Application No: EP/124/20/HH
Site Address: Little Dormers 23 Upper Drive East Preston BN16 1QN
Description of works: New bay and porch skirt roof to the front elevation, and roof linked detached double garage.

Thank you for your internet representation made on 25th November 2020 which has been recorded as an objection with the comments as follows:

Garage Plans and Elevations -
Proposed

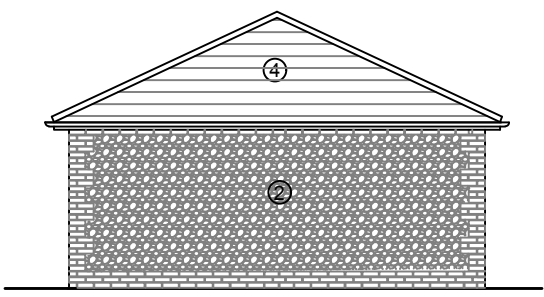
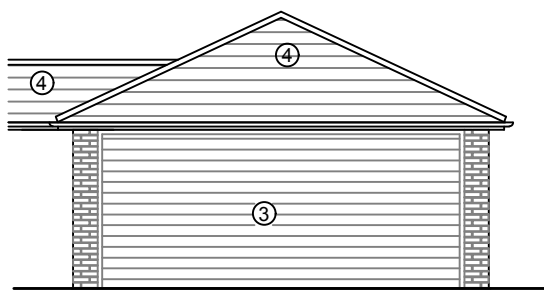
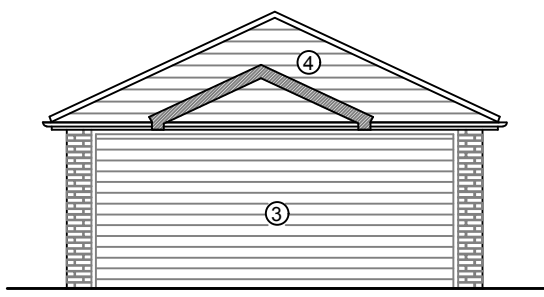
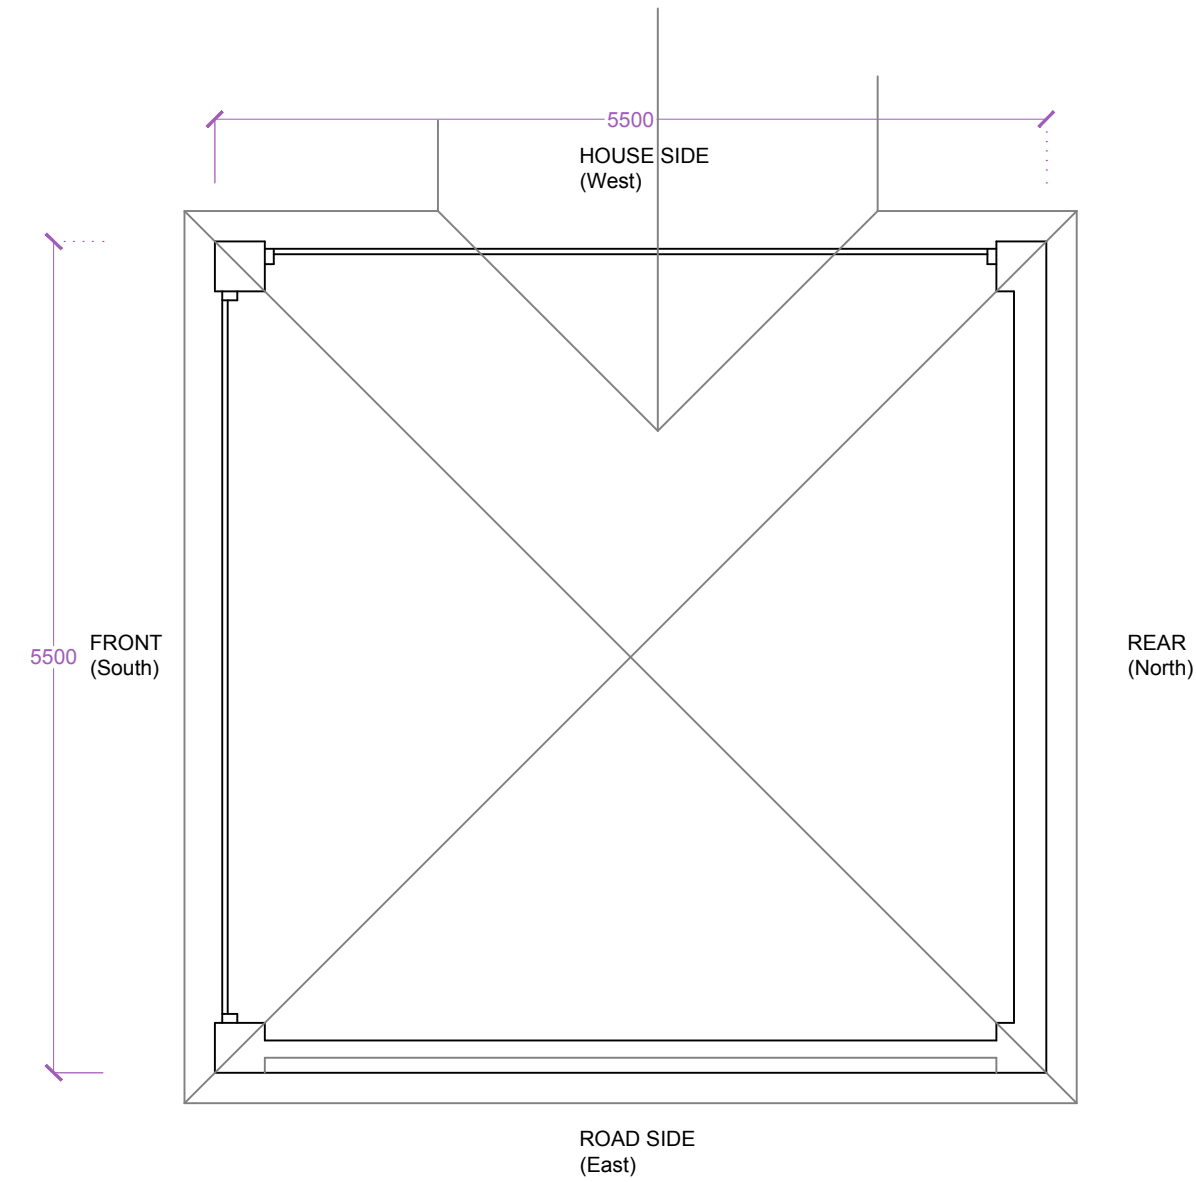
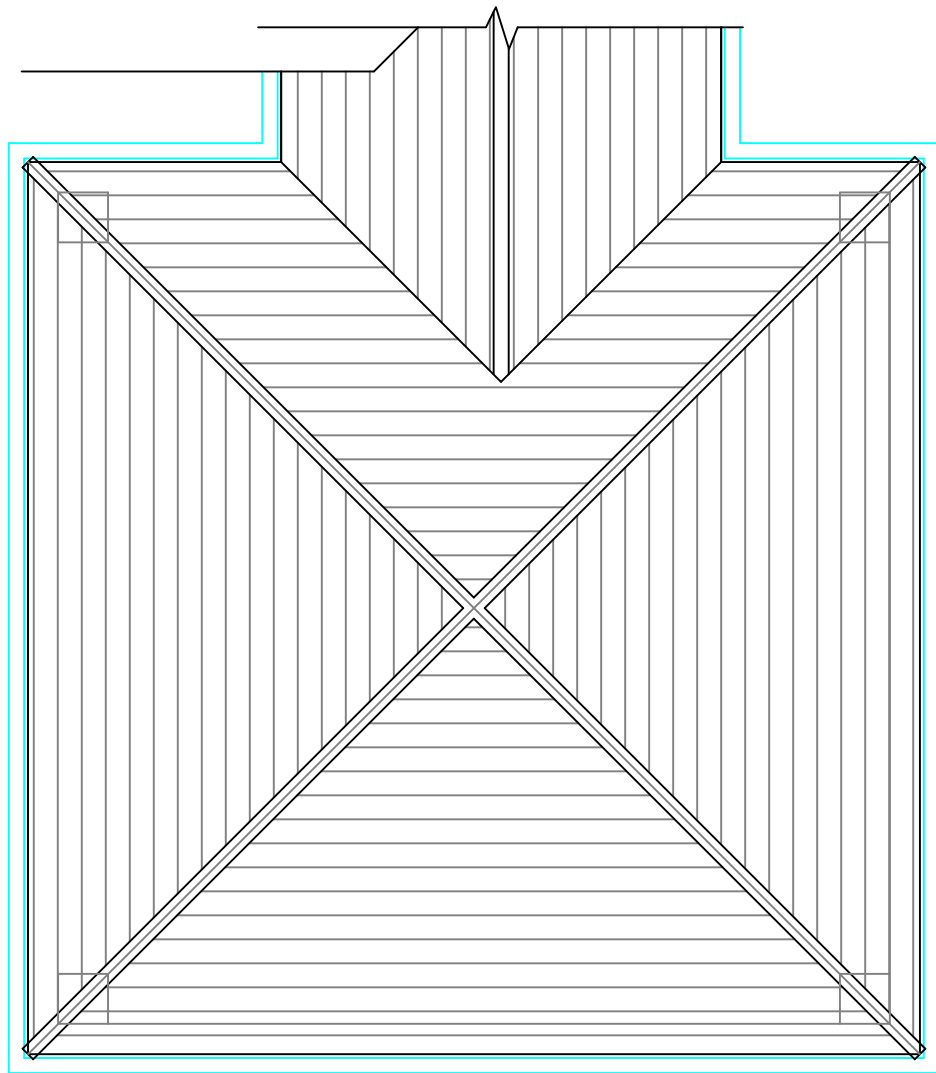
- the garage is too large for the suggested position (5.5m x 5.5m x 3.67m),
- its size and proposed siting will dramatically change the street scene, and
- it will have a negative impact upon the enjoyment of the front garden for its neighbours at No.25.
